Subject: Junction Rivers Wind Farm (SSD-30448824)

ATTACHMENT A – BCS and NPWS Assessment Summary for Junction Rivers Wind Farm Environmental Impact Statement (SSD-30448824)

ATTACHMENT B – BCS detailed advice for Junction Rivers Wind Farm EIS

Figure A.15 1% AEP flood hazard, existing conditions

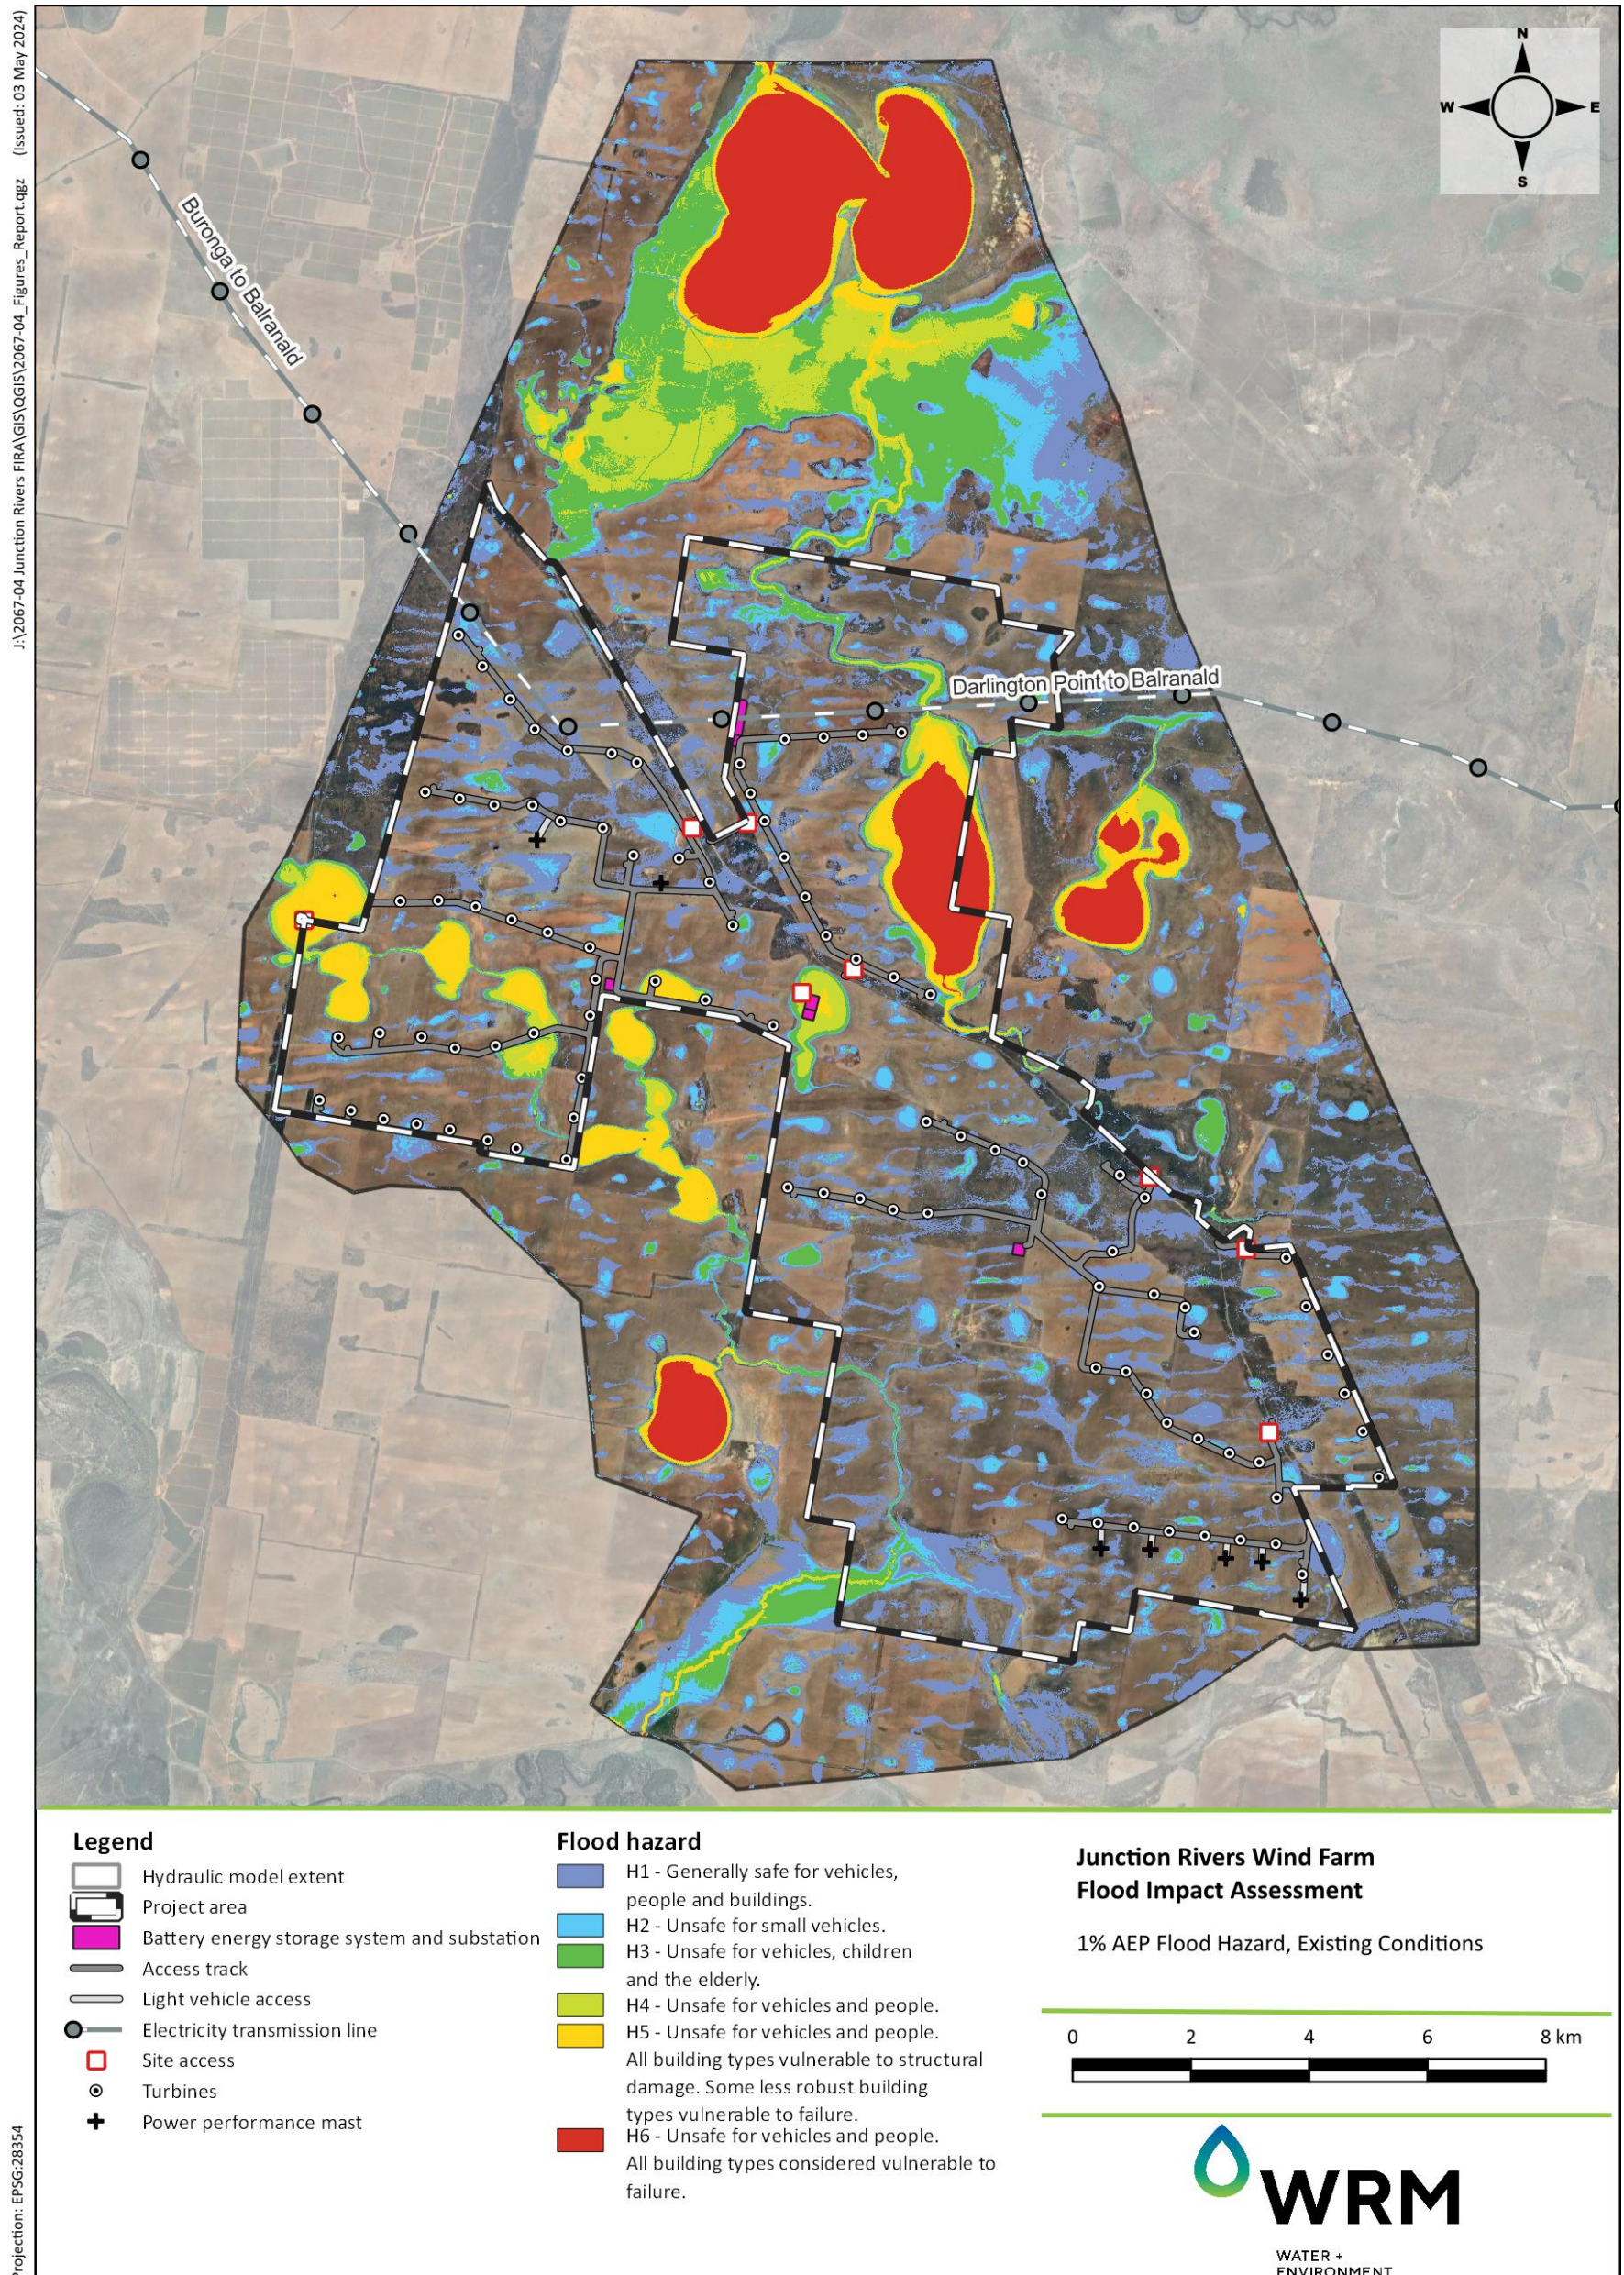
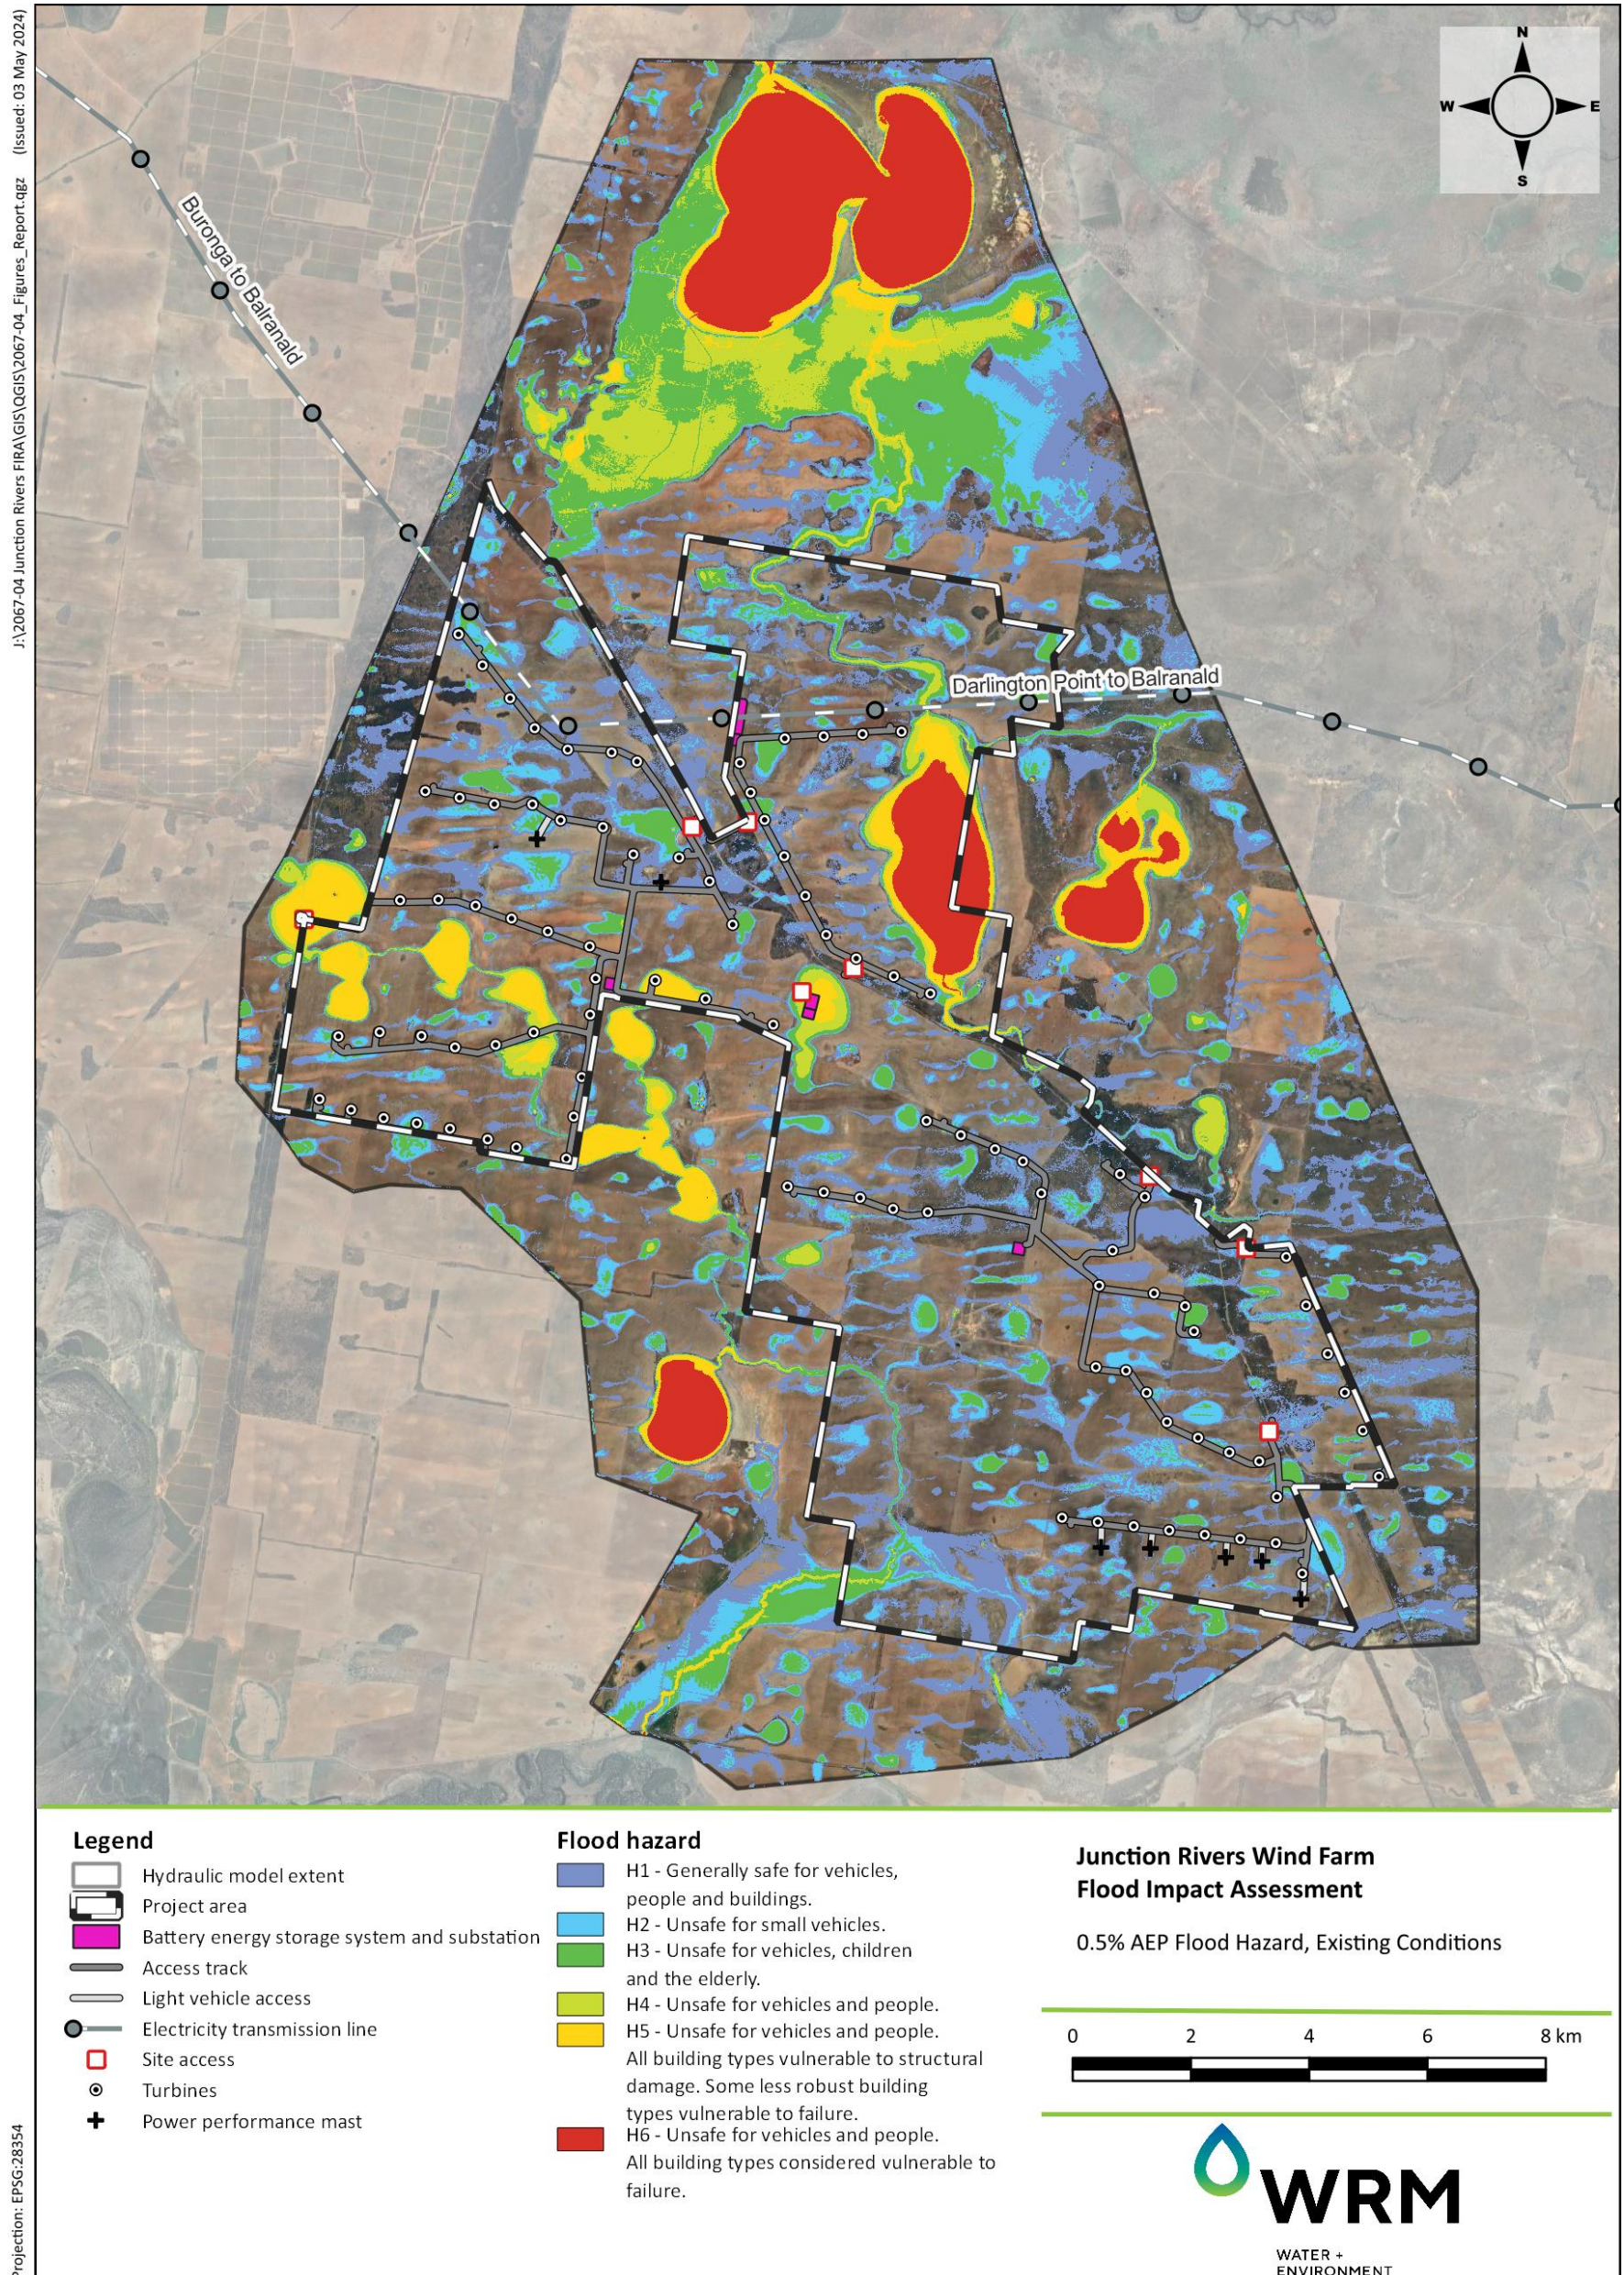
The proposed western and central site access points are located in high flood risk locations as shown in the design flood mapping in the Flood Risk Impact Assessment. BCS considers that these locations are incompatible with use as key evacuation egress routes in major flood events.

BCS recommends that more appropriate locations for flood emergency egress needs to be determined in the detailed design stage in consultation with local Councils and the NSW SES. The flood emergency evacuation egress locations and evacuation procedures need to be detailed in the proposed ERP along with the records of consultation with local Councils and the NSW SES.

- 2.1. Identify more appropriate locations for flood emergency egress for those site access points that are impacted by high flood risks in consultation with local Councils and the NSW SES.
